**Re: Sevano Place Subdivision Drainage report and Grading Plan
Grading and Drainage Plan
Engineer's Stamp Date 6-20-14 (C18D075)**

Based upon the information provided in your submittal received 6-20-14, the above referenced report and plan cannot be approved for Preliminary Plat action by the DRB until the following comments are addressed:

CITY PROJECT No.	ZONE MAP NO. C-18-7	SHEET 1 OF 2
------------------	-------------------------------	----------------------------

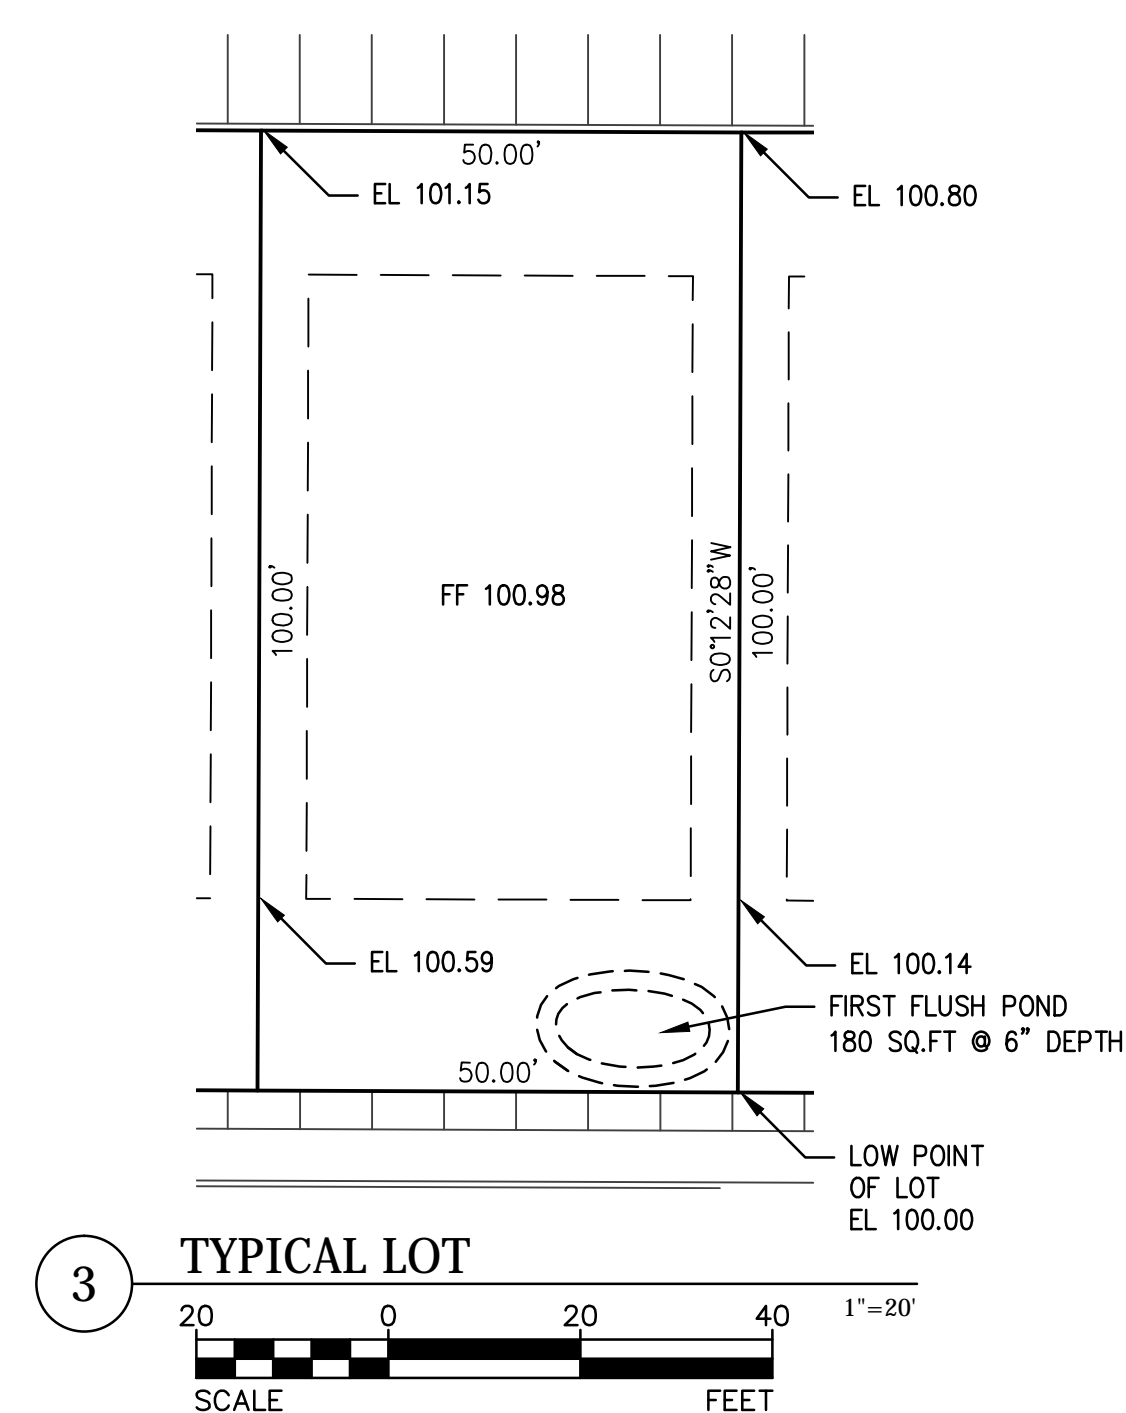
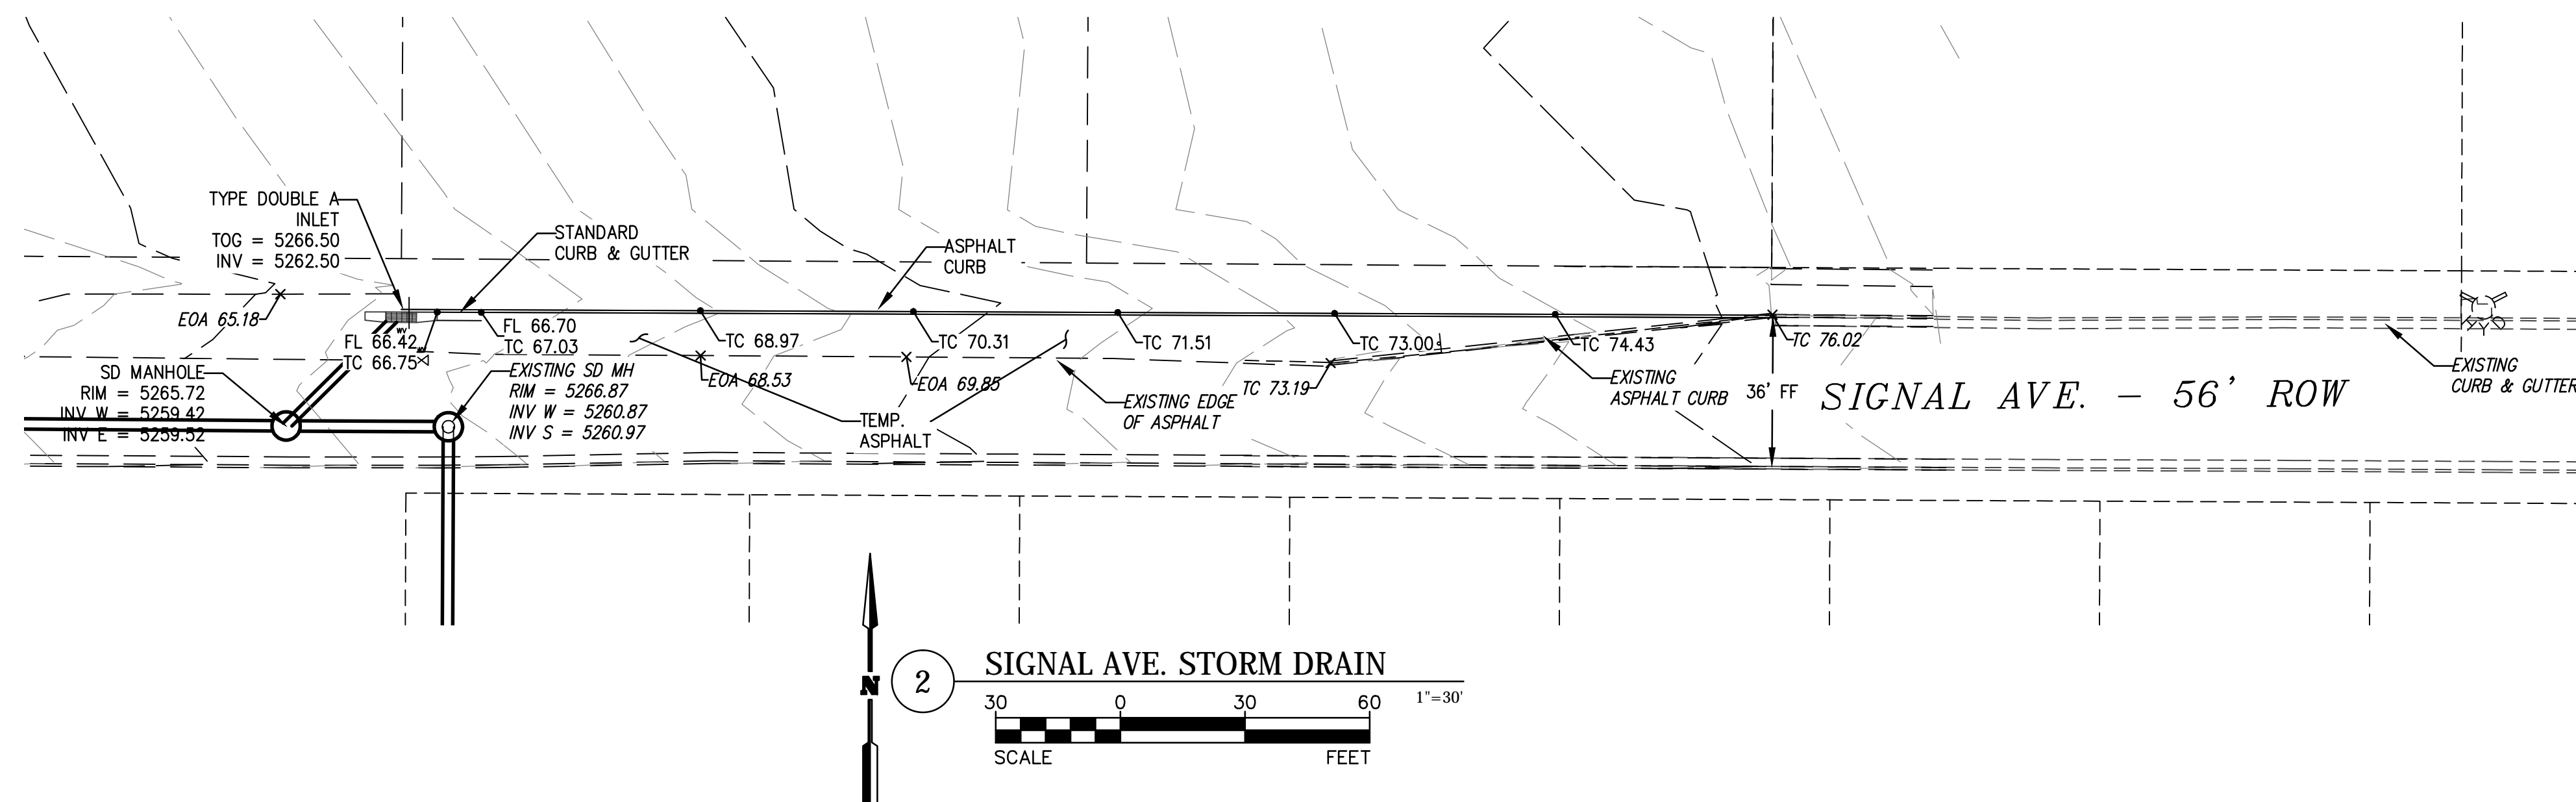
1. The drainage report is to state how the project will manage the first flush. A depressed front yard would be sufficient. This could be shown with one spot elevation on the grading plan and a detail for a typical lot.

3. The outfall to Signal Ave. should be designed so that there is a maximum of two -2 foot sidewalk culverts. The street may have to be super-elevated with standard curb to accomplish this. Hydrology did not see calculations in the report for this outfall. There should be a gap in the wall for an emergency spillway.

4. Hydrology has a similar comment for the outfall to Alameda Blvd. Provide calculations for the inlet and outfall pipes to the trunk in Alameda. The street should have a cross-slope, possibly super-elevation to the west.

7. Show temporary asphalt on the grading plan sheet 2 of 2 in between the existing edge of asphalt and the new curb.
8. The inlet on Signal should be a Type A since it is the furthest upstream.

9. A retaining wall should be proposed on the north side of Lot 18.
10. Is the sidewalk shown in the correct location on Alameda Blvd? Usually the back of sidewalk is at the property line.
